21st December 2016

State Significant Development Application for a Mixed Use Development at Site 9, Sydney Olympic Park (SSD 7445). Response to Department of Planning & Environment Comments

**General Arrangement Plan  
Ground**

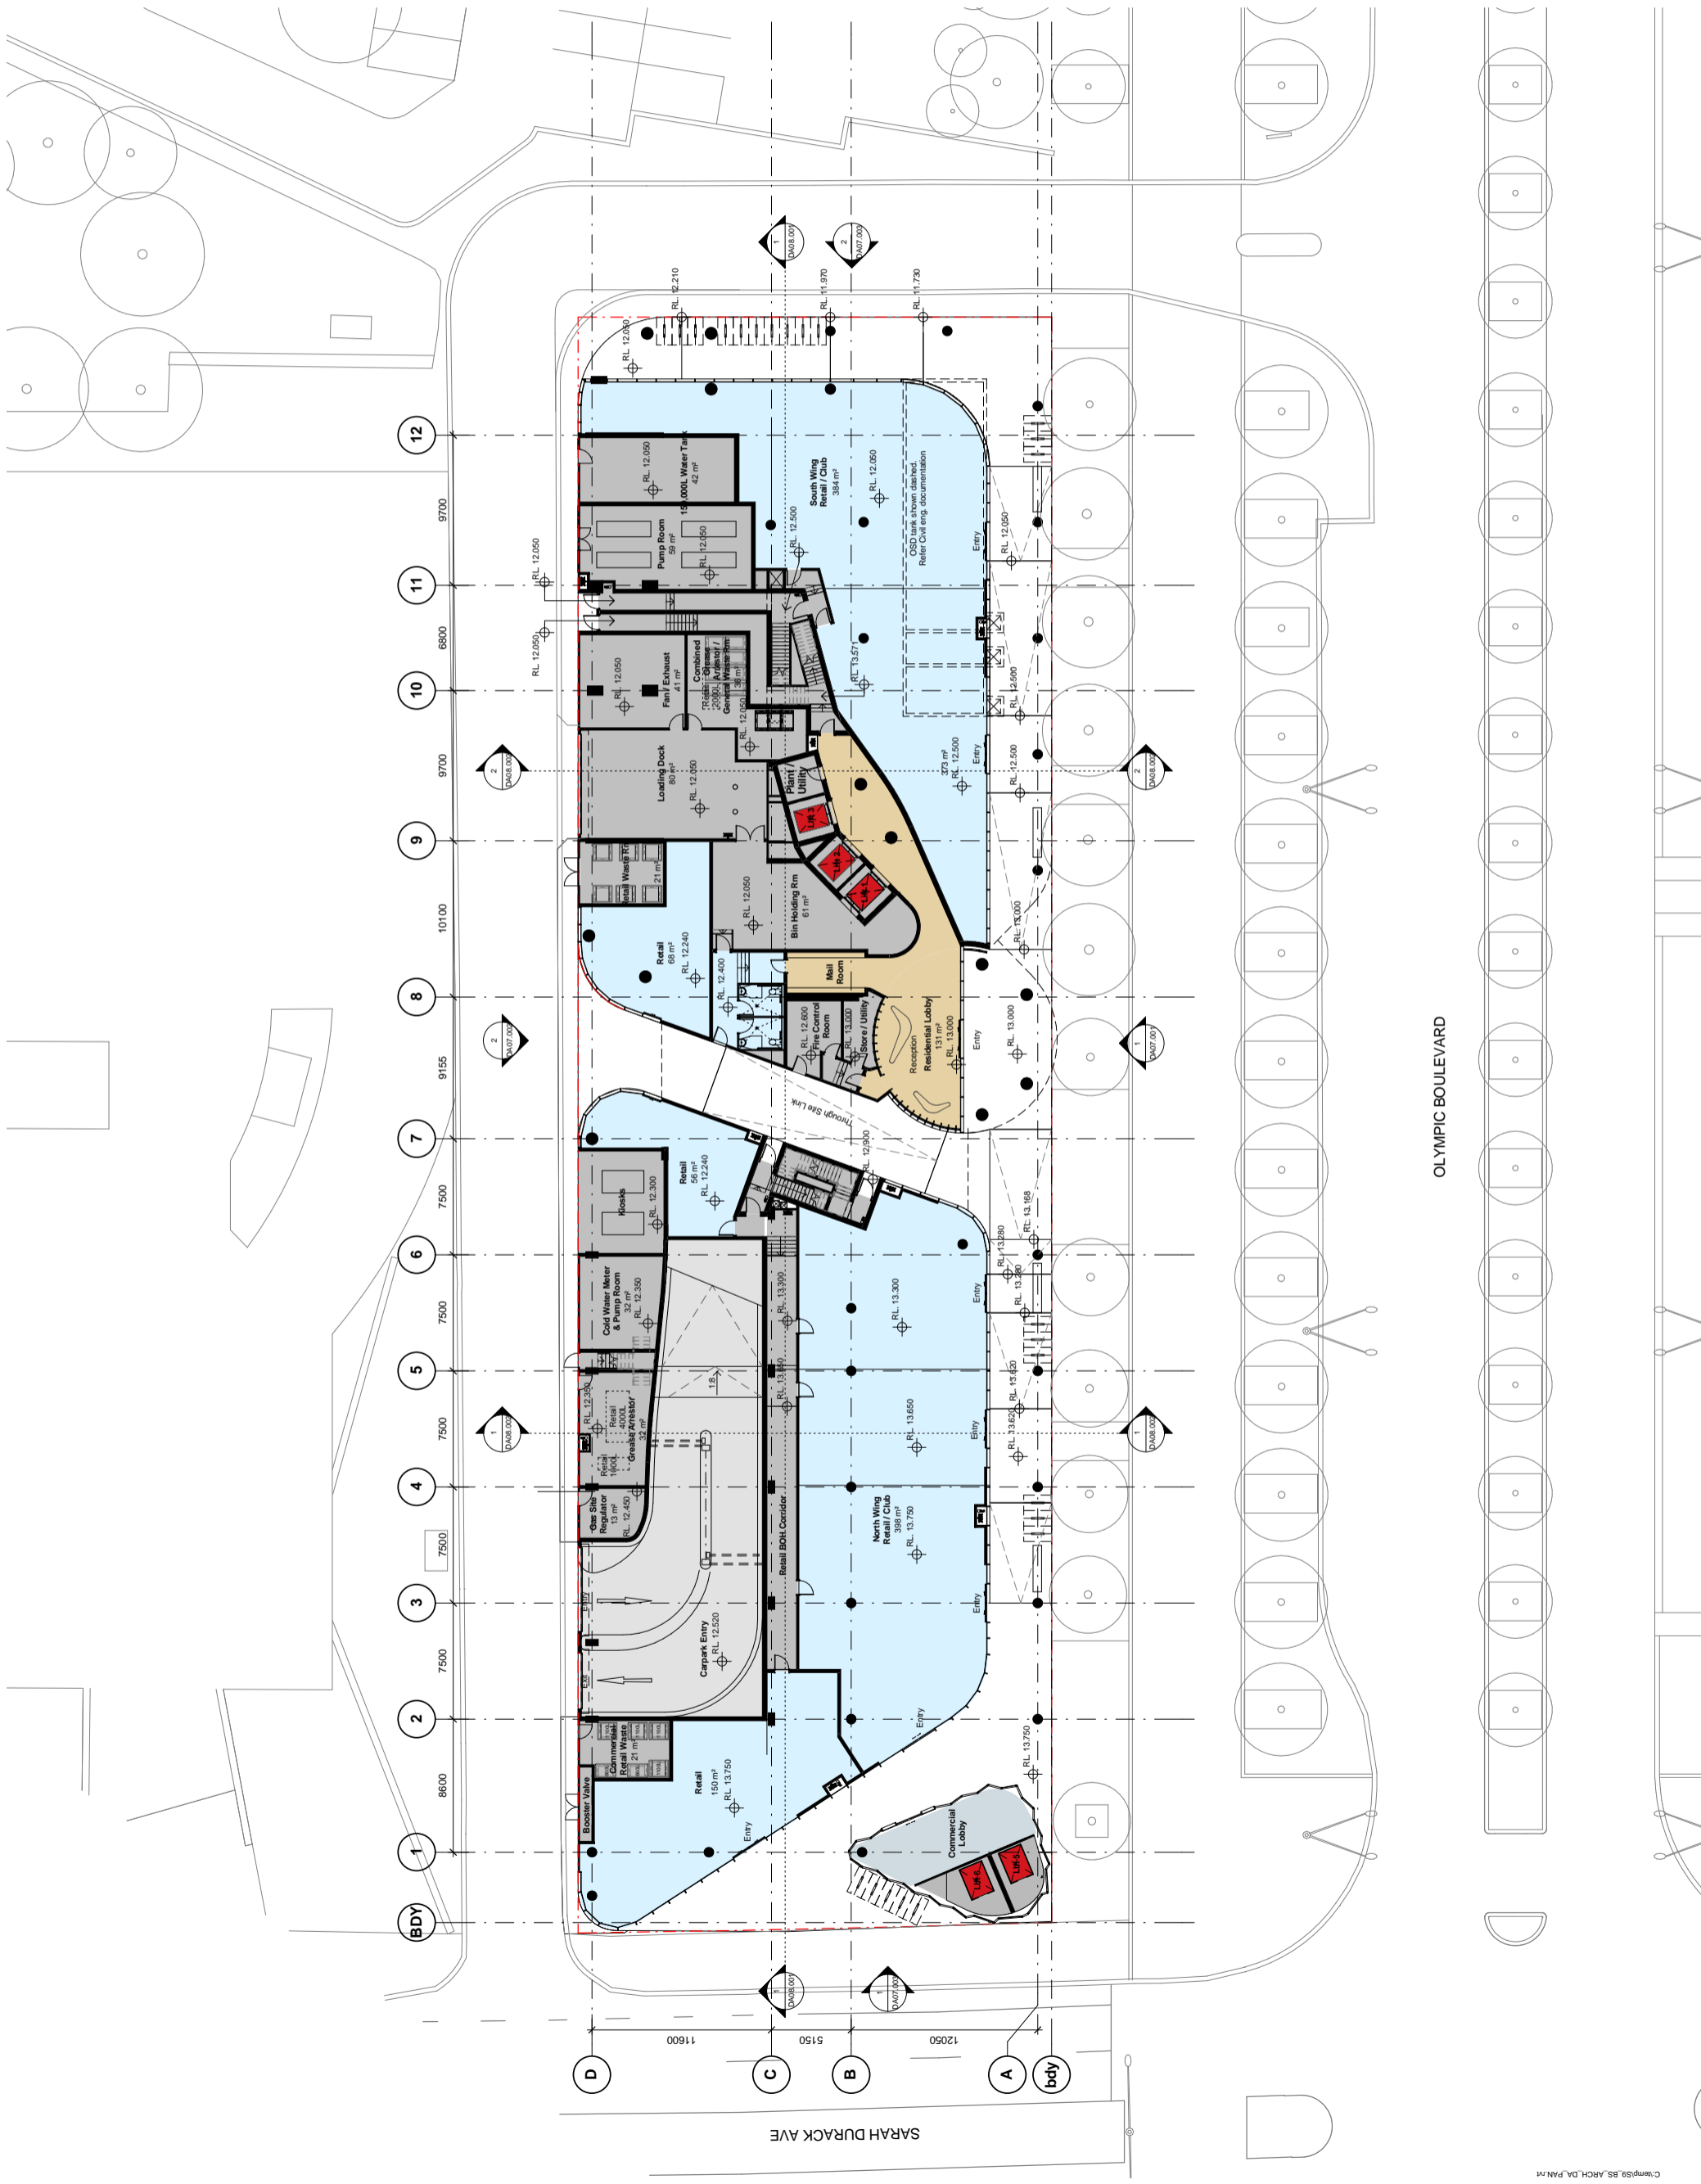
1. Bicycle Parking: Consider the provision of the resident and employee parking on the ground floor level, with secure street access, access to end of trip facilities and direct access into the building.
2. Vehicular Access: Identify the potential traffic impacts of the proposal on Sarah Durak Avenue and Olympic Boulevard and in particular as a result of vehicles queueing upon entering and exiting the site and measures to mitigate impacts.

As set out in Section 5.4 of the Parking & Traffic Assessment, the development requires a minimum bicycle parking provision of 390 spaces. These spaces have been distributed throughout the parking levels of the development including a provision of 106 spaces in one compound on Level 6. The spaces are located in proximity of the associated car parking spaces for the units or retail / commercial space, which is typical for a development of this form. The bicycle spaces are also located with good access to lifts and stairs within the parking levels, providing access to all parts of the building.

The provision of 390 spaces within the Ground Floor is likely to have a detrimental effect on the building form, with regard to services, loading, retail and club facilities, therefore providing an undesirable building form as a result.
